National Infrastructure Planning
 Temple Quay House
 2 The Square
 Bristol
 BS1 6PN

Your Ref EN010131
 Unique Ref: GABE-IP271
 Our Ref IPP-148
 Friday 1st September 2023

RE: Deadline 3 Response

Post-Hearing Submissions – written summary of oral submissions

FIGURE TITLE
 Environmental Parameters Plan
 Sheet 13 of 17

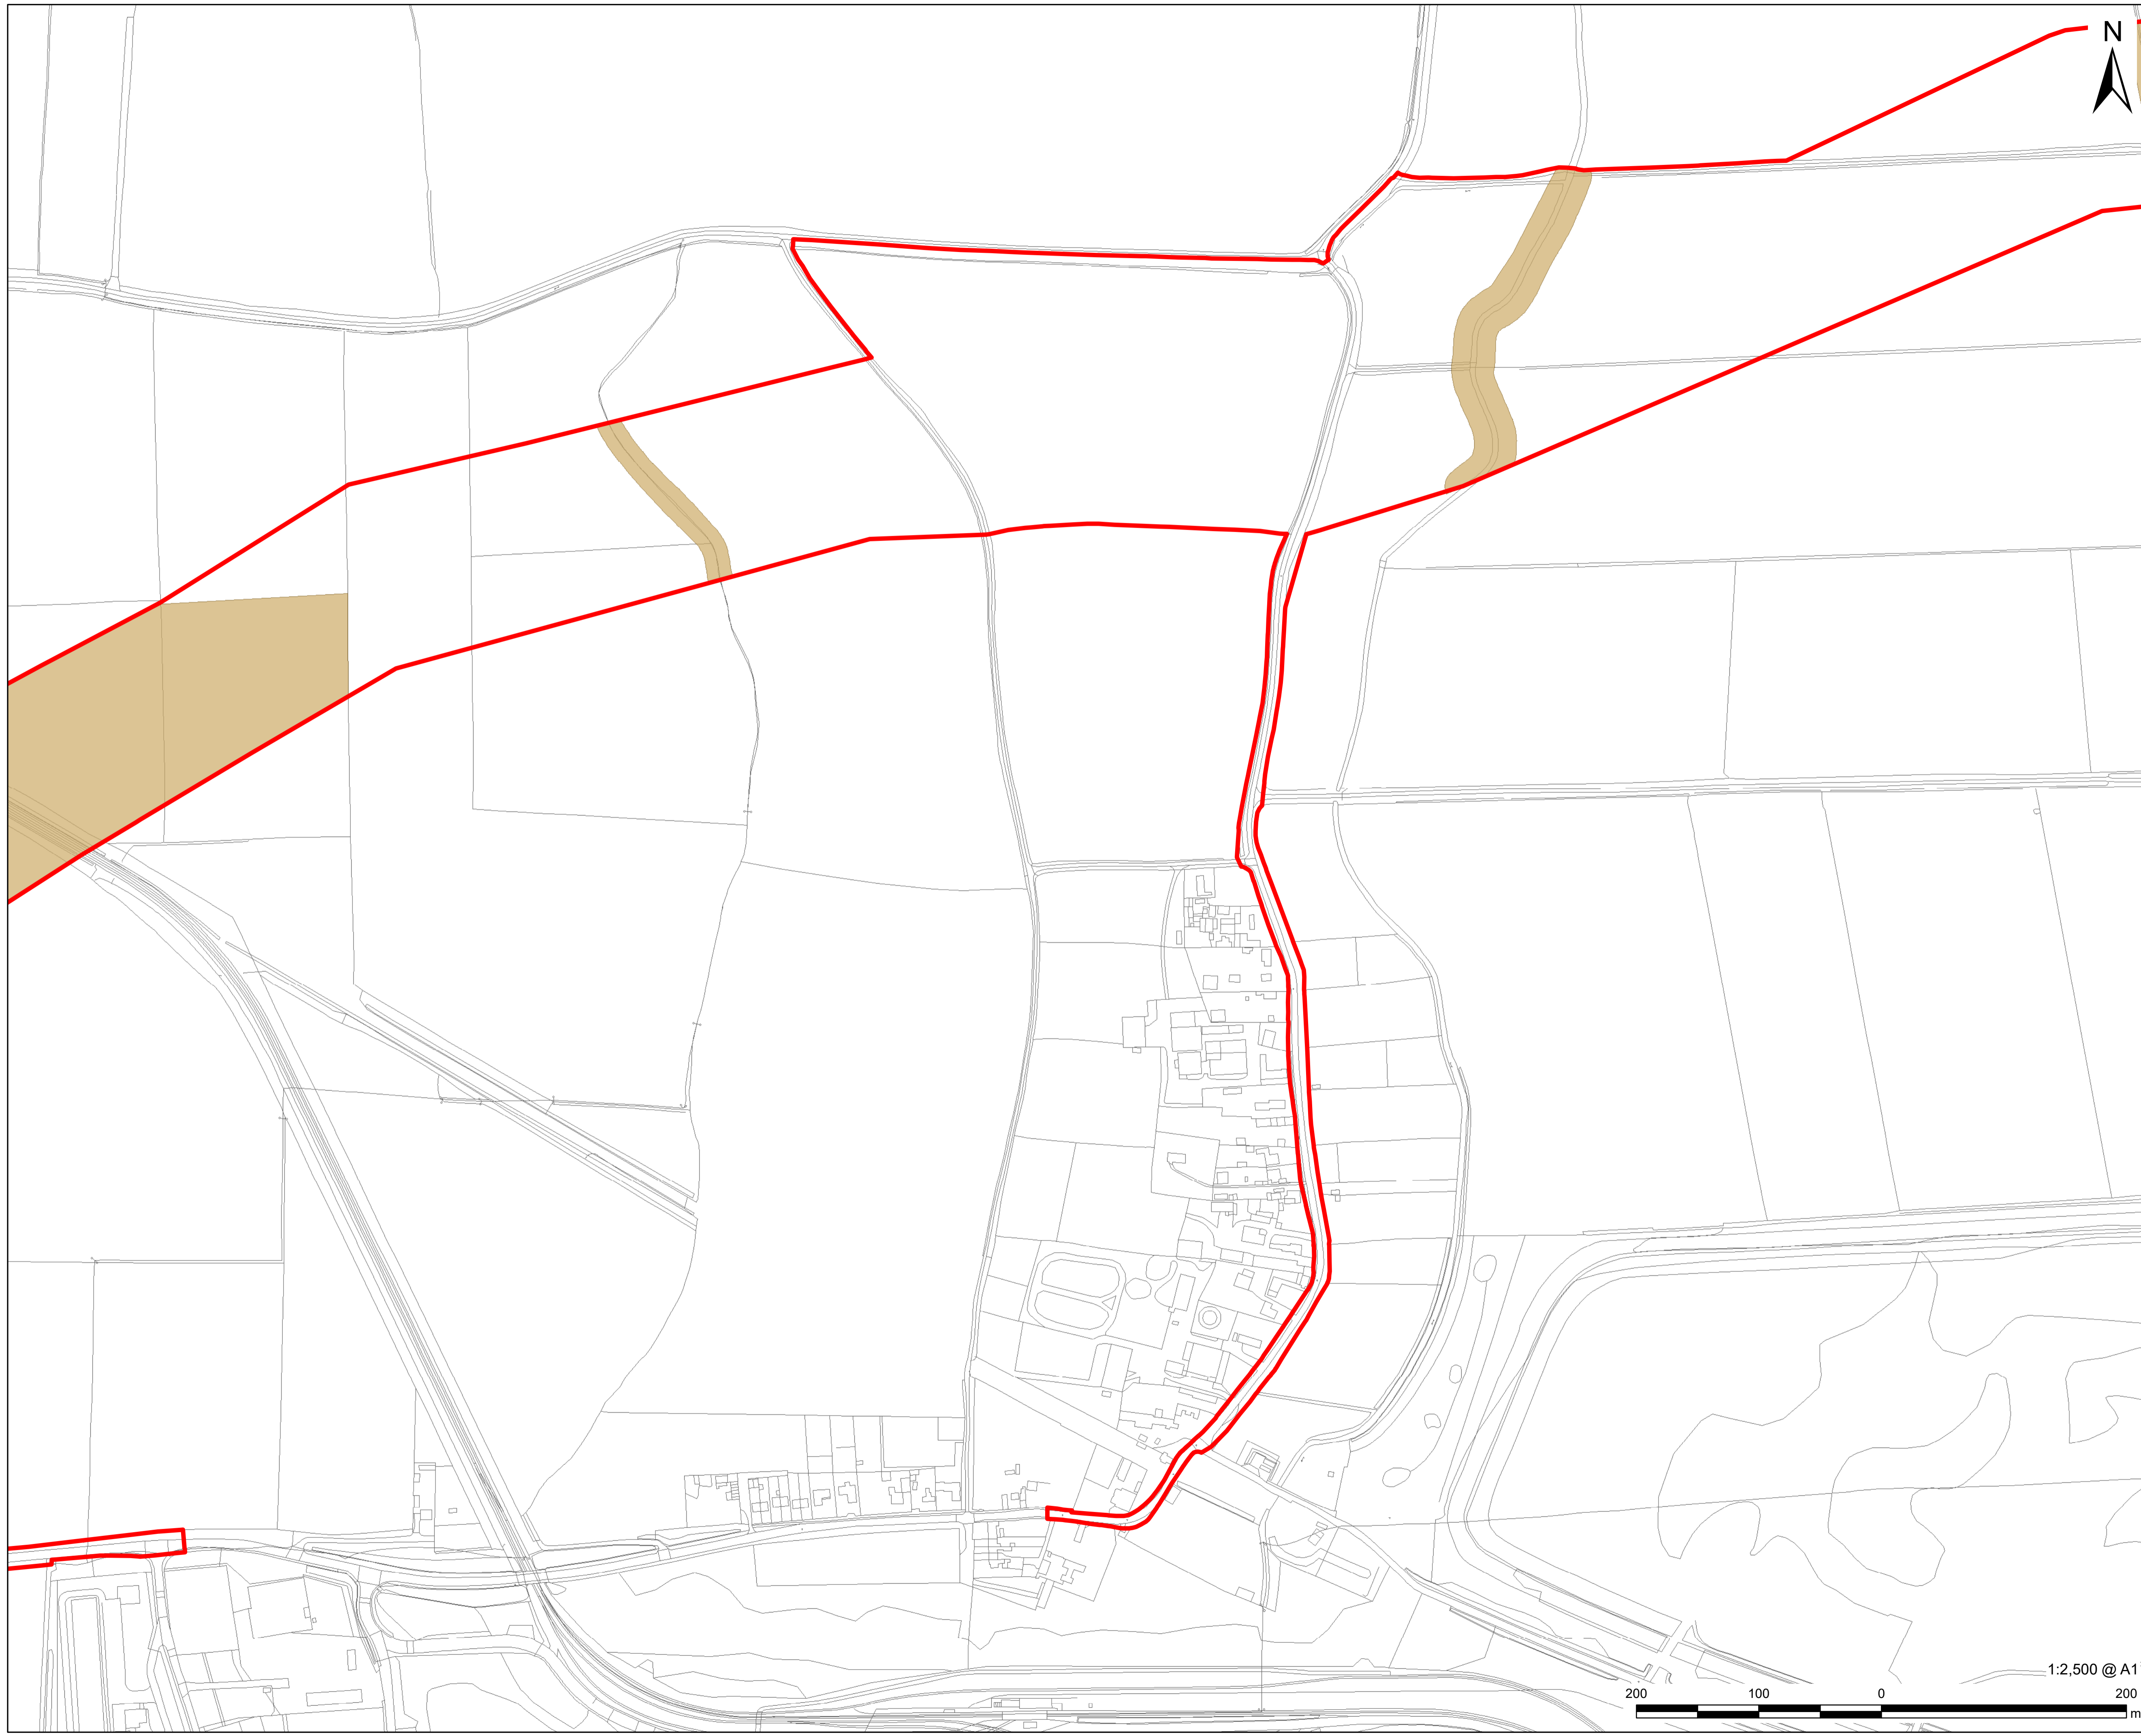
The Applicant has indicated that it would commit to HDD at a depth of at least 5m below the river and has indicated that it will amend the Outline Design Principles to reflect this. Accordingly, the Trust seeks an amendment to that document to specify that the HDD depth beneath the River Trent to be a minimum of 5m below the lowest surveyed point of the riverbed.
